Application Ref:	3/2026/0370			 Ribble Valley Borough Council www.ribblevalley.gov.uk
Date Inspected:	29/05/26	Site Notice:	N/A	
Officer:	AR			
DELEGATED ITEM FILE REPORT:				APPROVAL

Development Description:	Proposed demolition of existing garage, erection of new two-storey side extension and single-storey rear extension.
Site Address/Location:	62 Fairfield Drive Clitheroe BB7 2PS

Drawing Title
 Proposed Ground Floor Site Plan

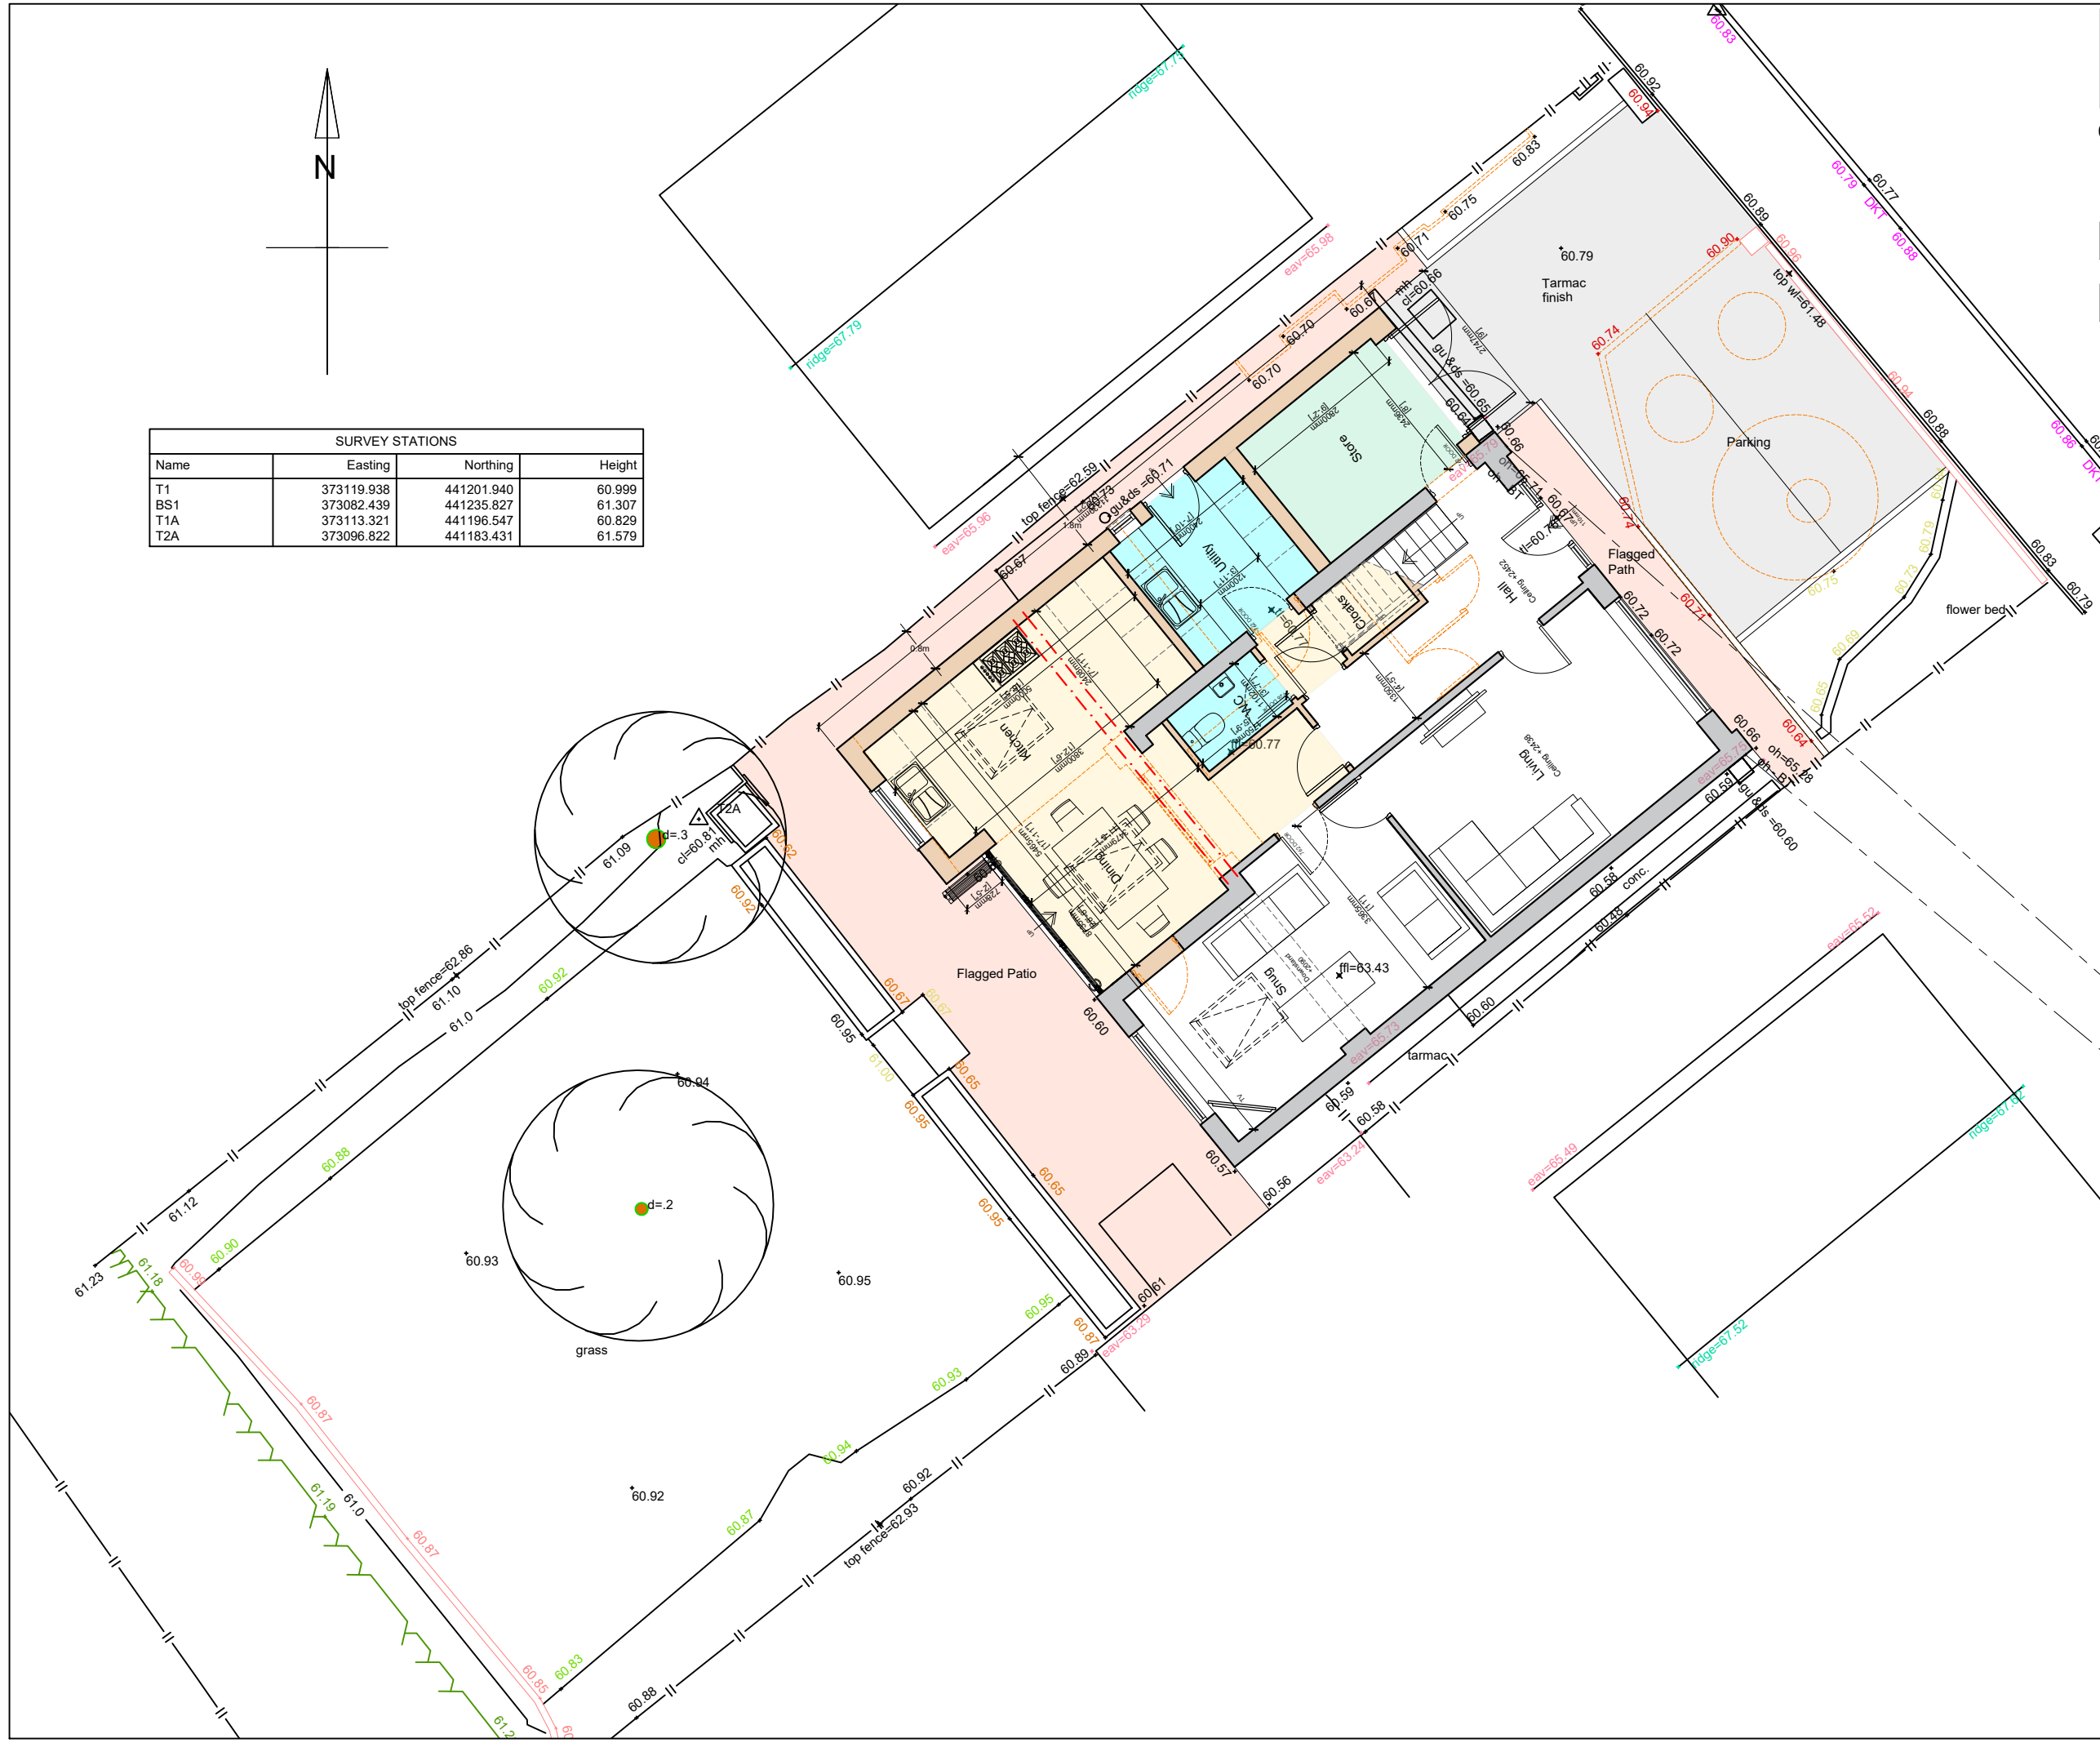
Desktop analysis and the proposed plans show that no.2 parking spaces can be accommodated on the front driveway, which aligns with the standard parking requirements. Therefore, with respect to parking, the proposal aligns with Policies DMG1 and DMG3 of the Ribble Valley Core Strategy.
